Appendix B – Submissions Response Table (SSD- 65924461)

Bayside Council		
Council has reviewed the submitted documentation and raises several objections, below. These objections are predominantly due to a level of missing or incomplete information to demonstrate how the proposal in its current form is suitable for the site and within the locality, and how some site-specific environmental issues will be managed. It is requested that the Applicant provides additional information to address Council's concerns.	Noted. See below.	N/A
Built Form		
<u>1. Site Analysis / Context</u> A detailed analysis has been provided to outline the primary constraints and opportunities of the site, establish fundamental principles for the development and explore several design options for the site. However, the architectural drawings still lack context as the proposed building is largely shown in isolation, and no elevation or section has been provided to show how the proposal relates to the low-density residential context of Stephen Road. A clear and accurate depiction of how the proposal relates to the low-density residential context of Stephen Road has not been provided.	An updated set of Architectu

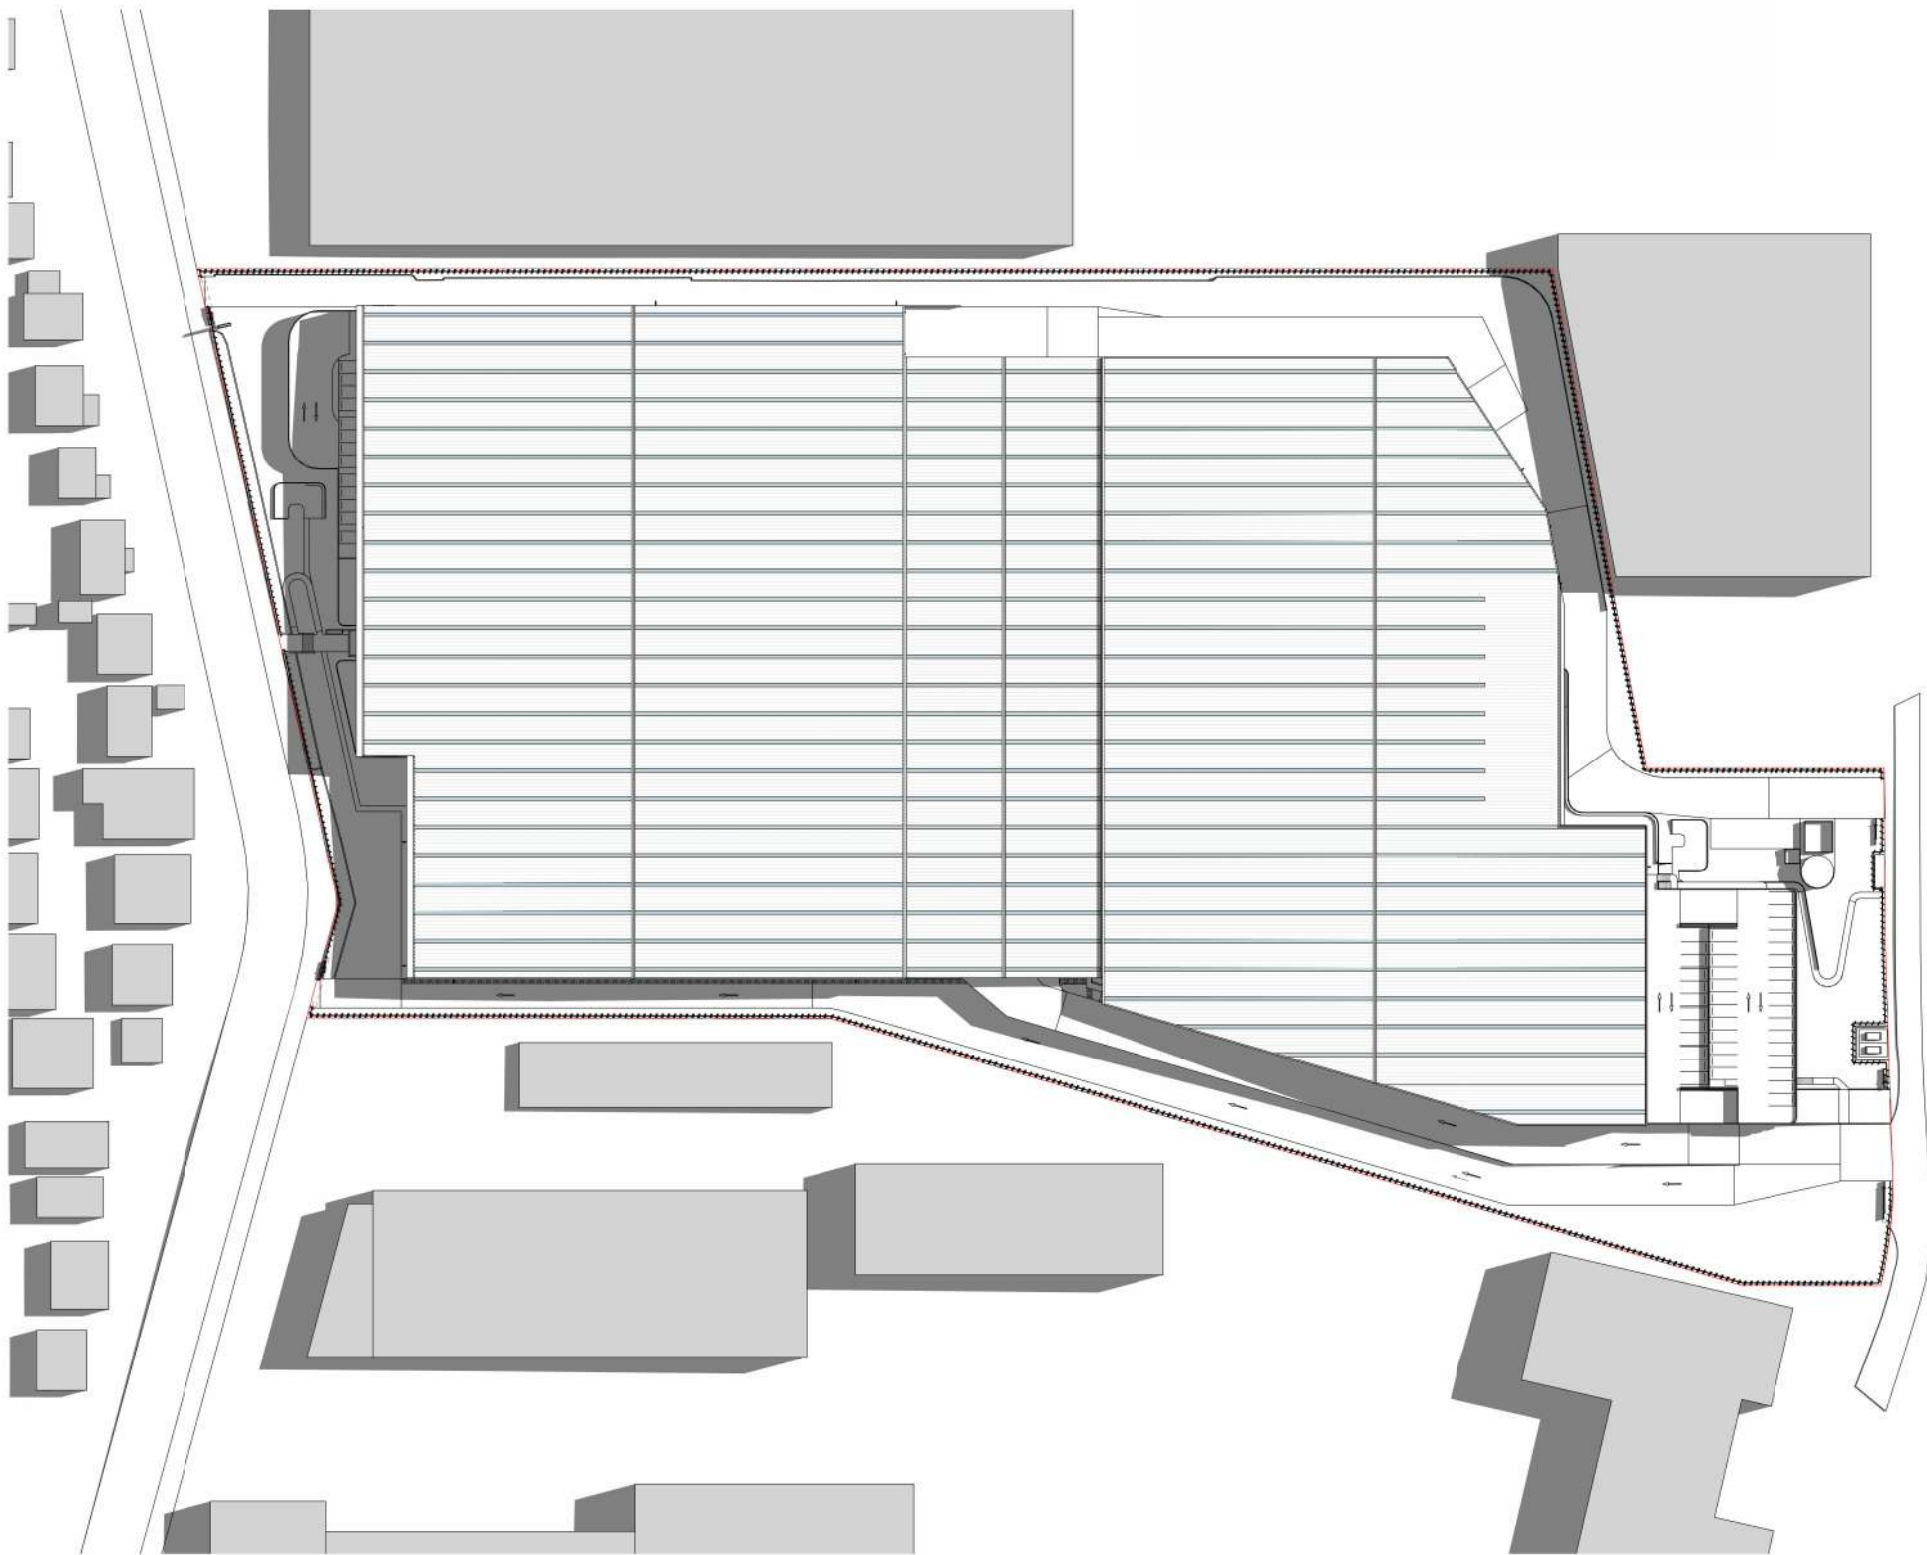
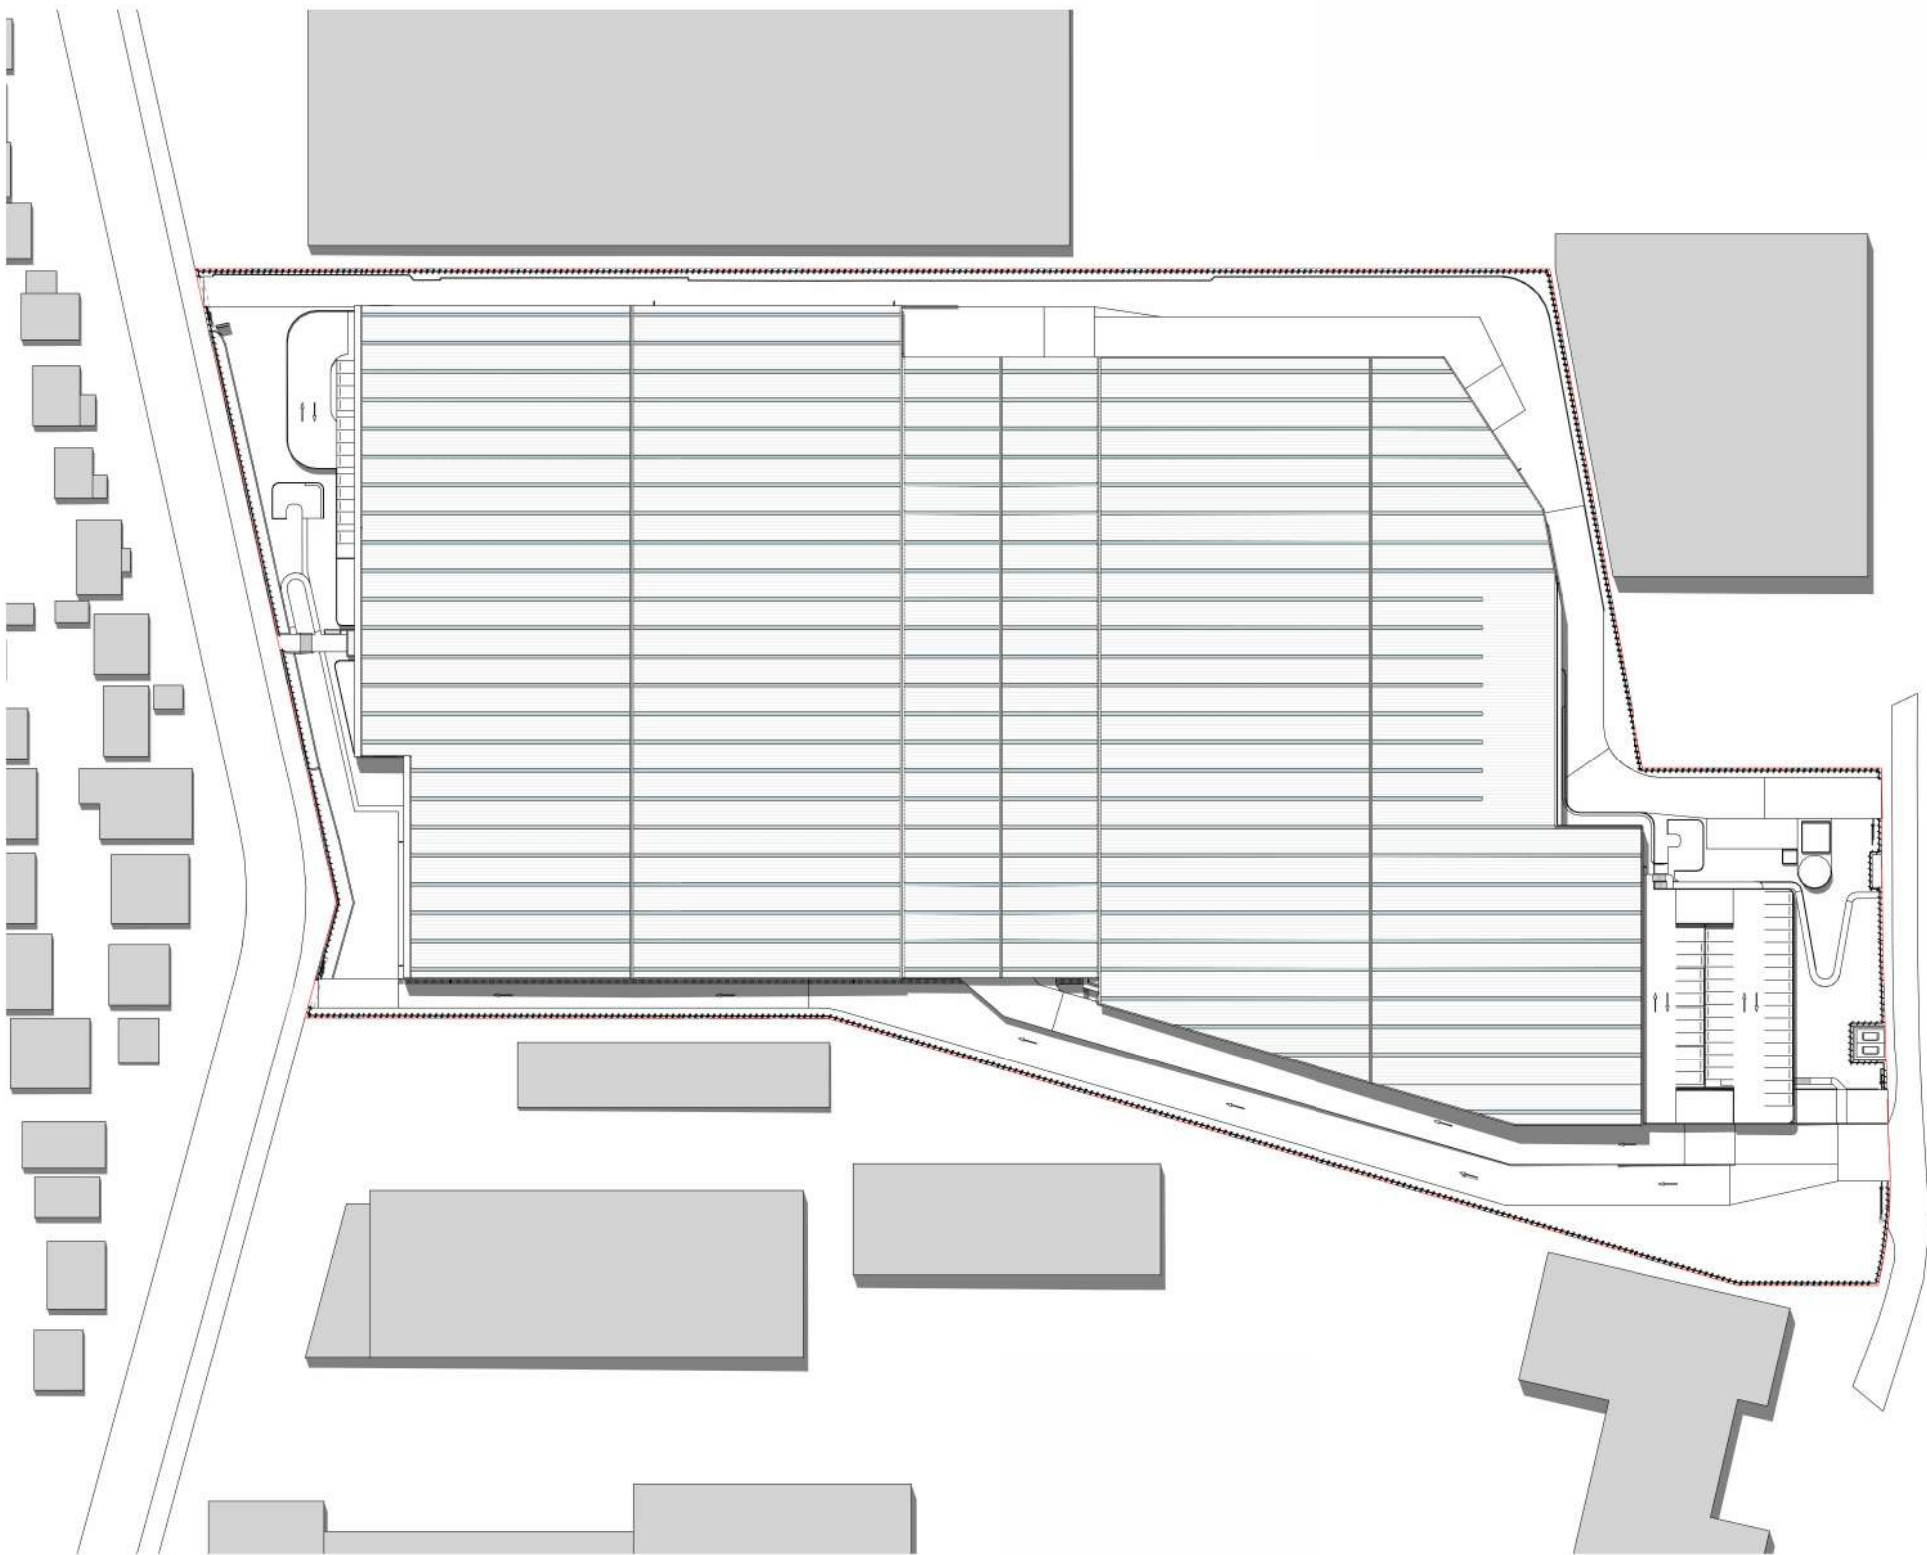
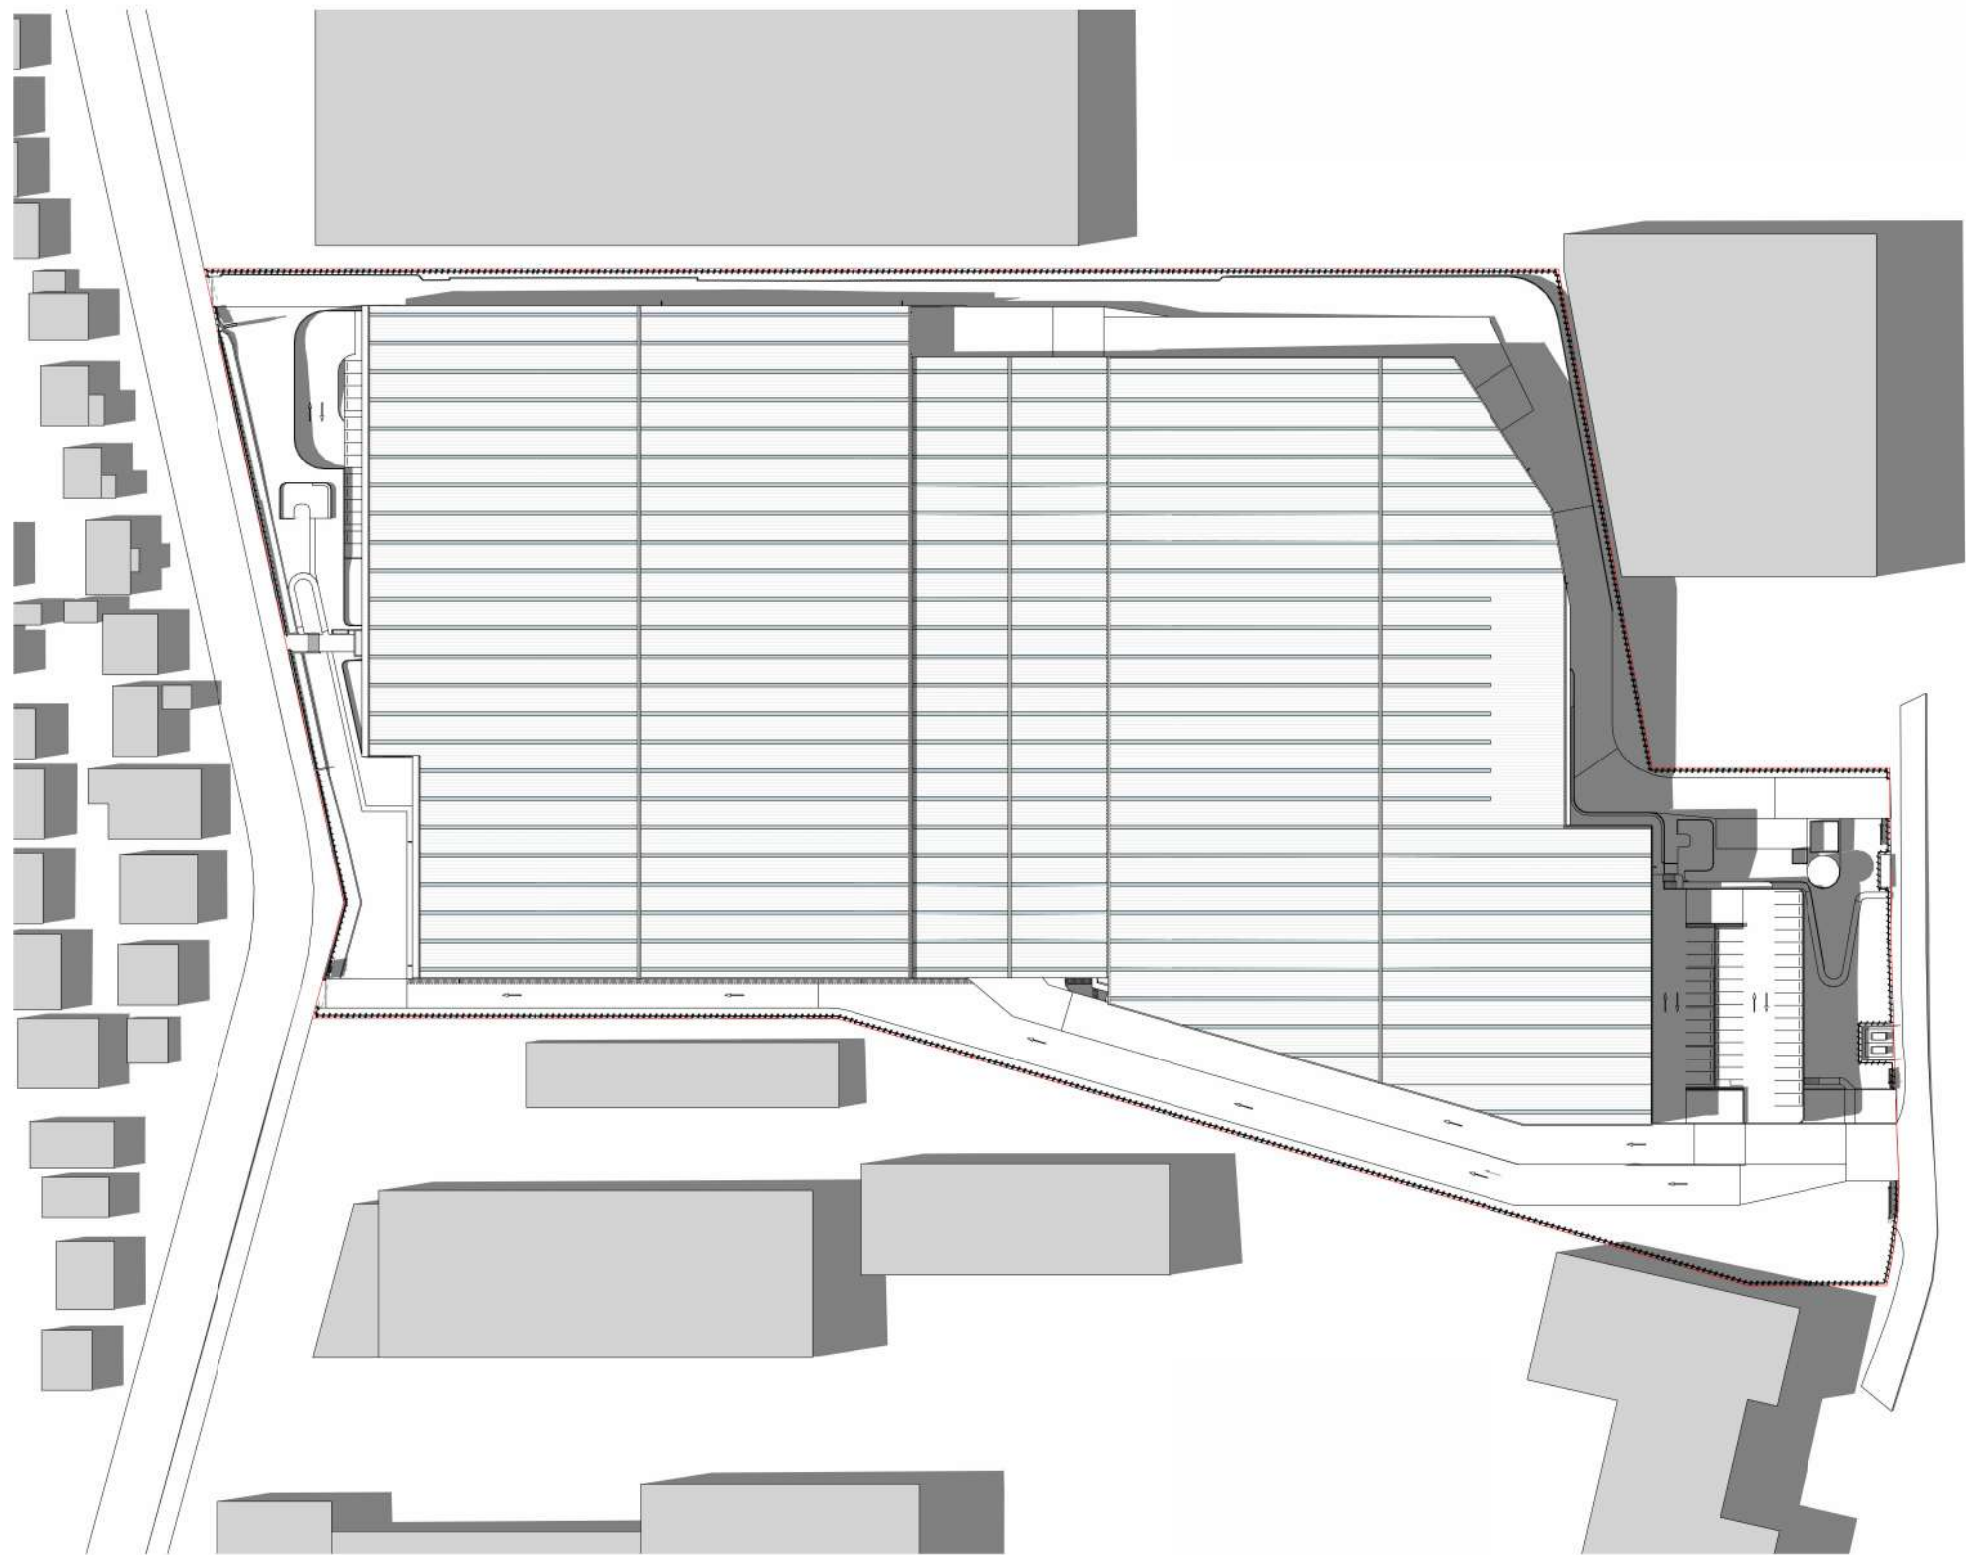
4. The Department raises concerns over the shadowing impact the proposal will have on residential properties opposite the site on Stephen Road, particularly during winter mornings. Revising the buildings interface with Stephen Road by reducing the scale of the building will likely assist in minimising the impact on solar access to the sensitive receivers.	Further to the above, updated shadow diagrams provided in the revised Design Report demonstrate that the two-storey scheme results in significantly less overshadowing than the previous design. The reduced height, increased setback, and larger landscaped buffer along the Stephen Road frontage work together to improve solar access to dwellings opposite the site. The revised footprint also limits the amount of warehouse floor space positioned directly along the boundary, further minimising bulk and shadow impacts.	Appendix F Appendix I

4. <u>Solar Analysis</u> A review of the solar analysis and shadow diagrams provided in the Design Report, prepared by SBA (dated 18 November 2024), appears to show some discrepancies in depicting the extent of shadow cast over Stephen Road. The section in Figure 2 shows the shadow cast at 10AM, mid-winter as being approximately 49.6 metres in length. This is approximately 10 metres longer than the shadow shown on Page 30 of the Design Report (Figure 3). It is also noted that the position of residential dwellings depicted on shadow diagrams are not included in the survey drawing provided. Further information is required to clearly and accurately demonstrate the extent of overshadowing to existing residential dwelling on the western side of Stephen Road.	The revised two-storey design results in significantly less overshadowing impacts than the previous three-storey design. There will be no overshadowing of any dwellings, with a minor intrusion into the private open space along Stephen Road at 9amm which is considered a minor solar impact. New shadow diagrams have been provided in the updated Design Report at Appendix I.	Appendix I
